CITY OF PORTLAND

Job ID: 2012-07-4524-ALTCOMM

has permission to build a 138 square foot (egress) stairwell addition.

From: Jonathan Rioux
To: davidleasure@myfairpoint.net
Date: 9/12/2012 9:25 AM
Subject: 695 Stevens Ave.
CC: Pirone, Chris; Wallace, Benjamin

STAIR SECTION - "A-A"

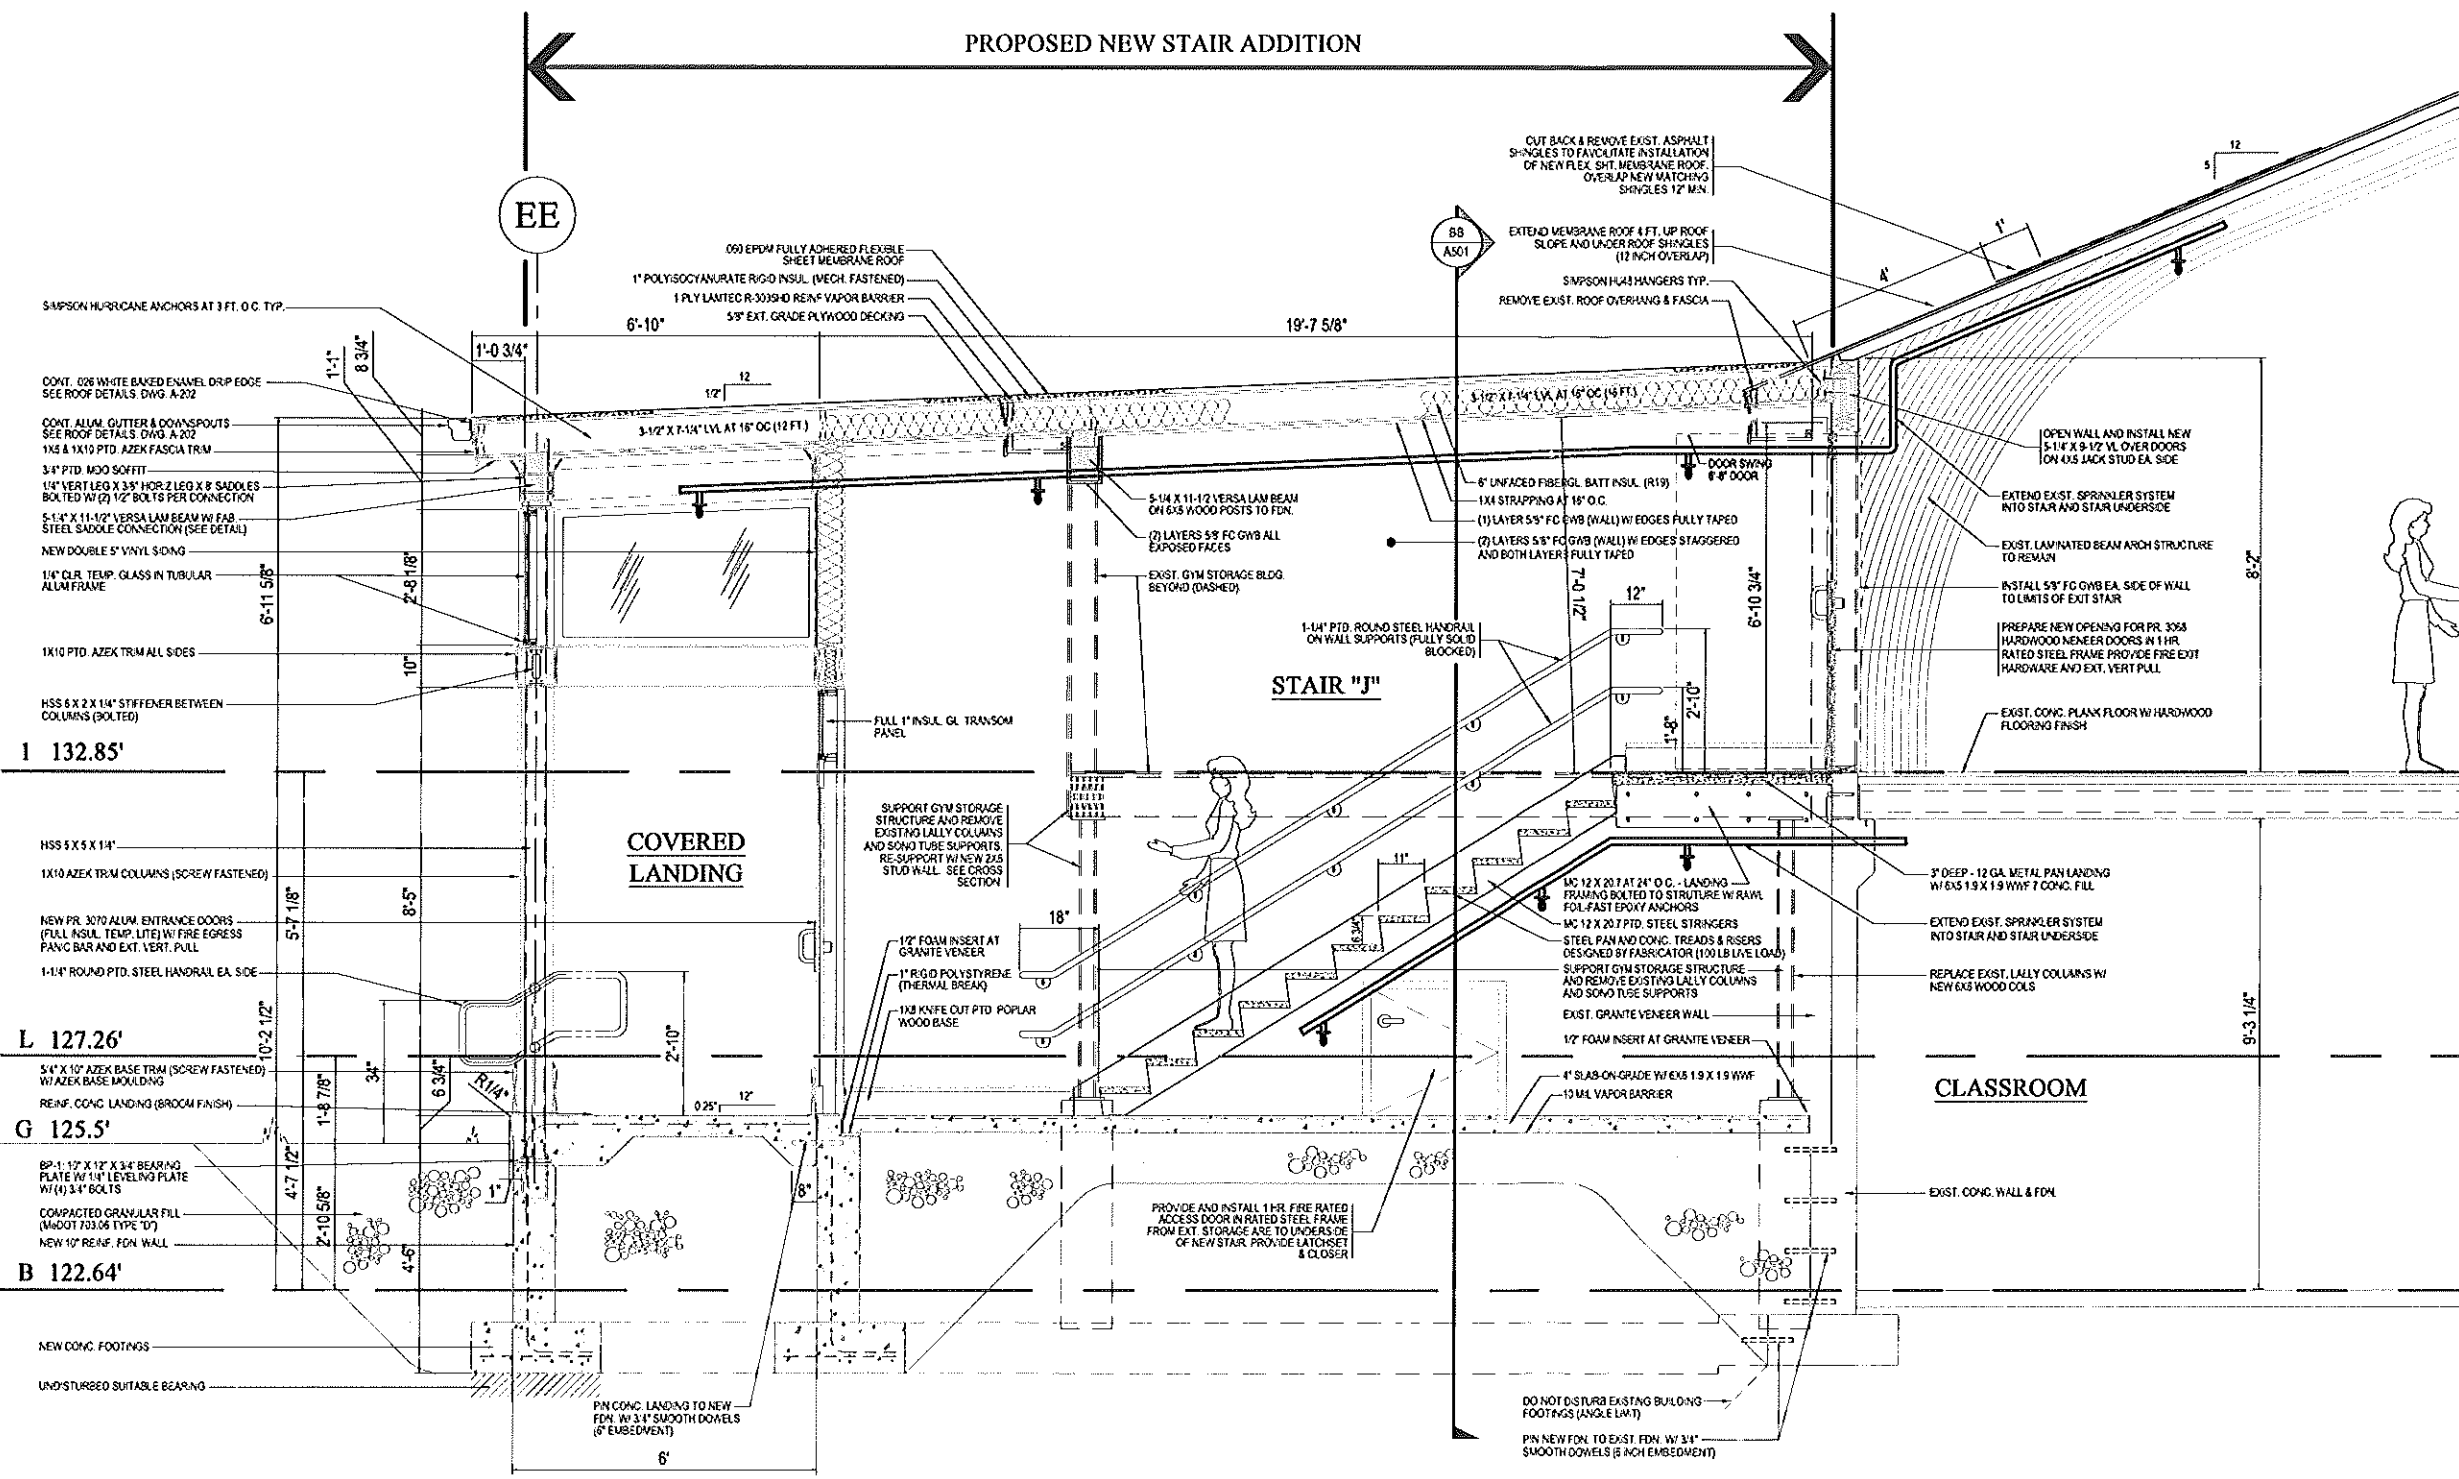
- The submission indicates the stair is to serve as a required means of egress but does not provide a life safety plan indicating occupant load of the space being served and how that's be accommodated. Need a complete seating plan and egress arrangement for the space. I don't believe the gym was approved for assembly use prior to this, and I think that change must be what has triggered the need for another exit and capacity.
- The headroom for the new stair does not comply with 101:43.8.1.1(1) and 101:7.1.5 for headroom at the top landing and door.
